Engineers Comments Regarding Surface Water Drainage

Application Reference:	F/22/26/DOC	Reviewer Reference:	ADC/EXT4b
Planning Officer:	Simon Brooksbank	Date of Review:	15/09/2026
Site Name:	Land at Ford Airfield Ford		
Application Description:	Approval of details reserved by condition under F/4/20/OUT relating to conditions 28- Proposed foul drainage system, 29- Proposed surface water drainage scheme, 30- Discharges to watercourses and 31- Maintenance & management of surface water drainage system.		
Assessment Number:	2 of 2

PLAN ON FLOW CONTROL MANHOLE

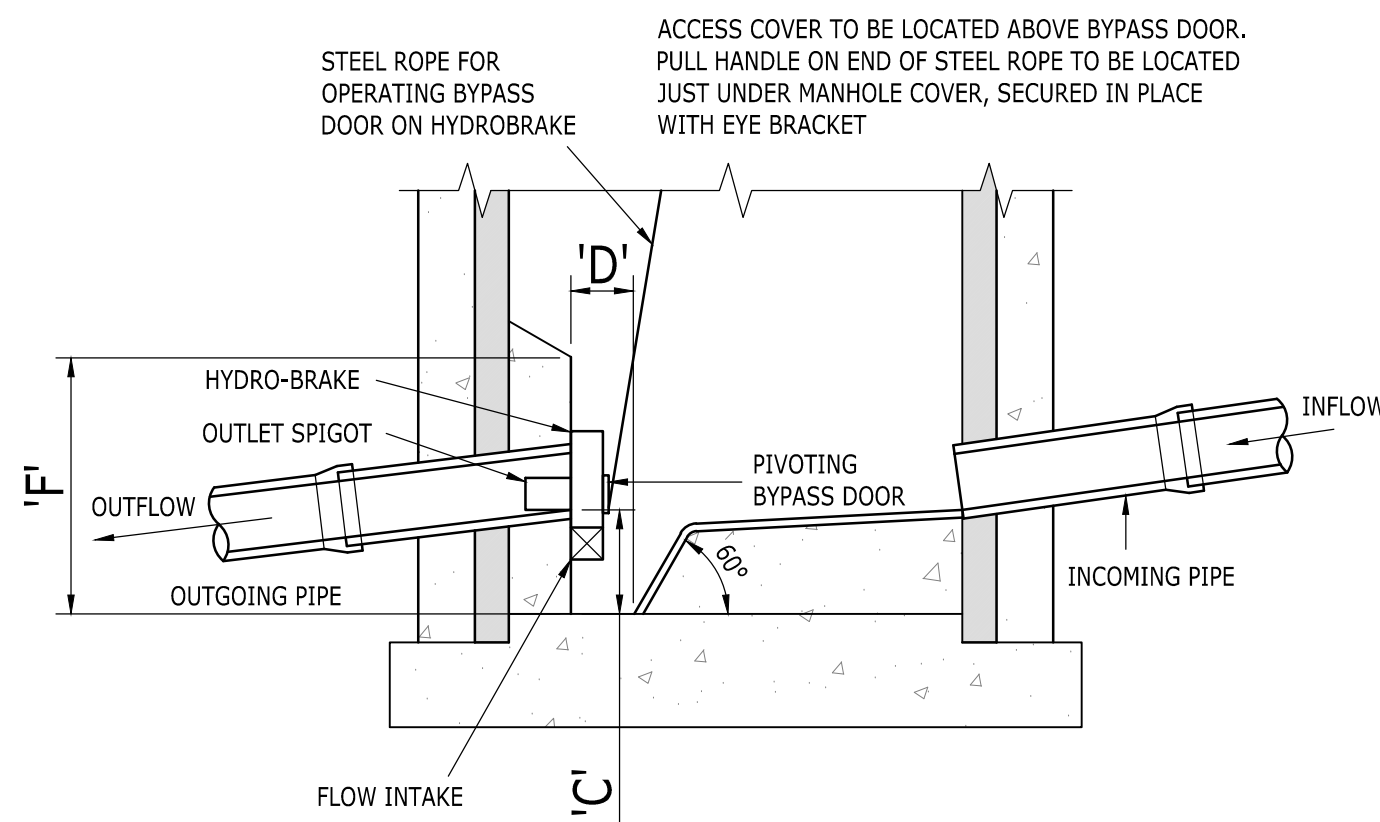
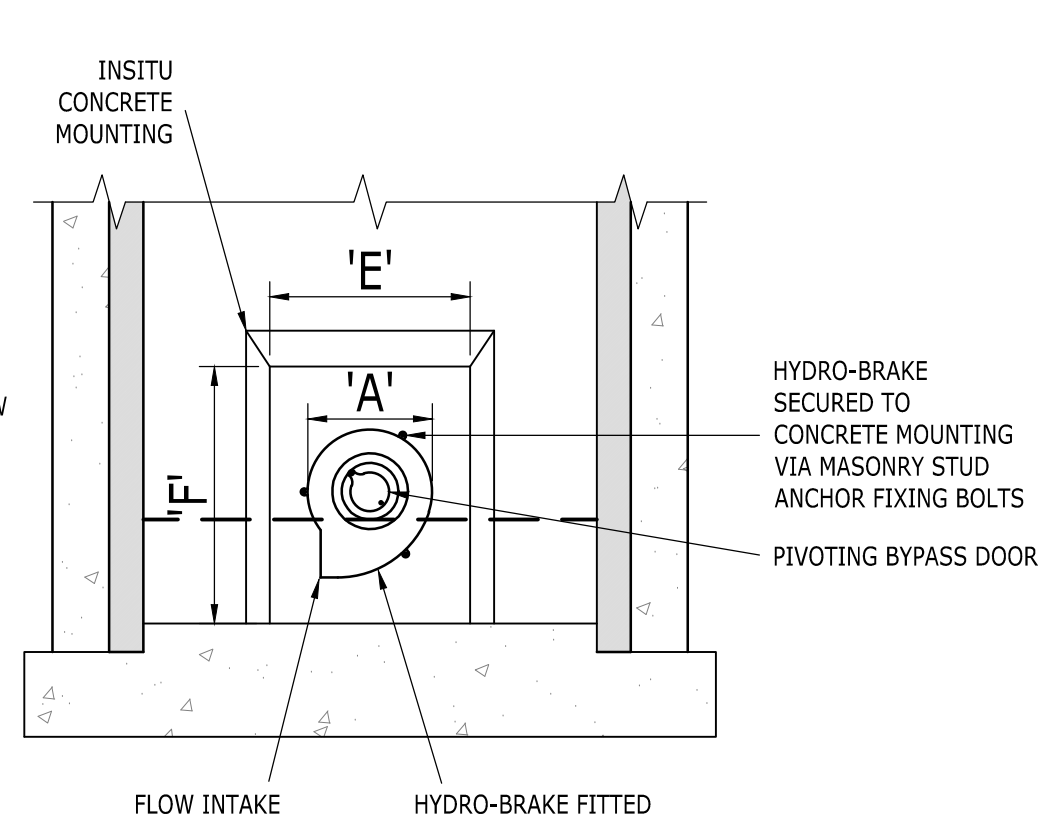
23.	Please check design heads on hydrobrakes – on 289 the depth on the 1 in 100 year + CCA event exceeds the design depth.	Updated calculations have been provided in Appendix B.	These still do not correspond. Invert level of 293, plus the design depth is exceeded for all hydrobrakes except 464 in the 1% AEPP + CCA. The discharge rates from 293 and 520 exceed the design rate.

26.	The hydrobrake dimension table is useful, please also include the invert and cover levels plus incoming and outgoing pipe diameters on this.	Updated drawings are provided in Appendix A. The hydrobrake dimension table has been amended	Thank you point closed.

Peak flow within Pozidrain membrane

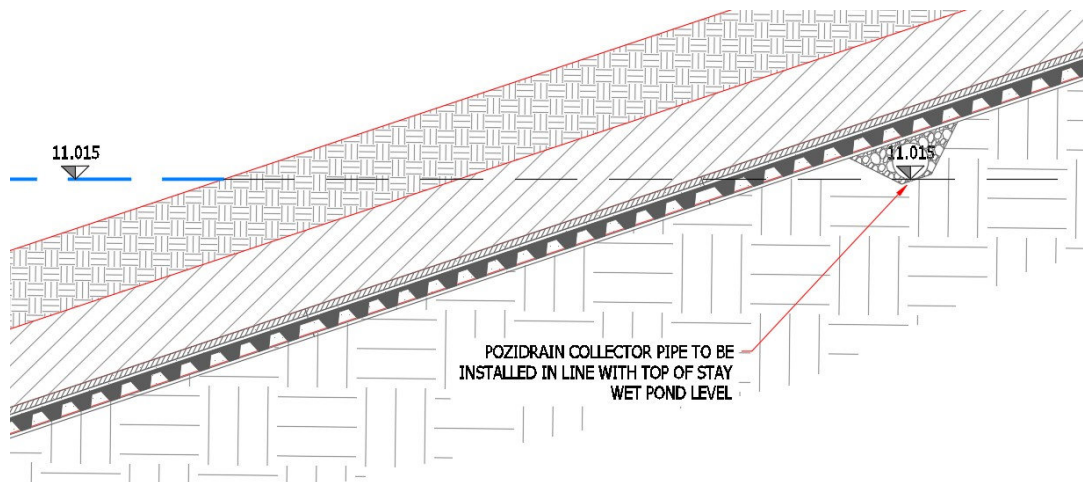
15.	Please provide further explanation of how uplift force is accounted for in the	Due to unavailability, the Pozdrain system has been switched for the EnkaDrain	Enkodrain do not specifically reference groundwater and uplift

buoyancy calculations. The hydraulic conductivity of the clay should be based on site specific testing, not BS 8004. Please also submit written confirmation from pozidrain stating that they have reviewed the calculations and design and agree that the these are appropriate for their system and that it will perform the function it is designed for (to relieve uplift forces on the basins).	system which functions in the same way. The submitted calculations for the basins are to determine the flow rate through the EnkaDrain system which manages the buoyancy forces on the basins. The implementation of the EnkaDrain system effectively removes the buoyancy force and introduces a minor additional flow rate (as calculated). Enkadrain do not sign off engineering designs as they are a product manufacturer. However, EnkaDrain list this as a valid product use on their website (https://www.geosyn.co.uk/product/enkadrain).	force (buoyancy) relief as a use. However, it is acknowledged that the webpage states that the system “Reliably prevents hydraulic pressure build-up in soil layers and under structures”. The page appears to refer primarily to percolating water and landfill capping uses. As such, the company have been approached to confirm that the product is suitable for, and tested for this purpose. If the applicant can submit this evidence then that is also satisfactory. The point regarding the hydraulic conductivity of the clay remains unanswered.
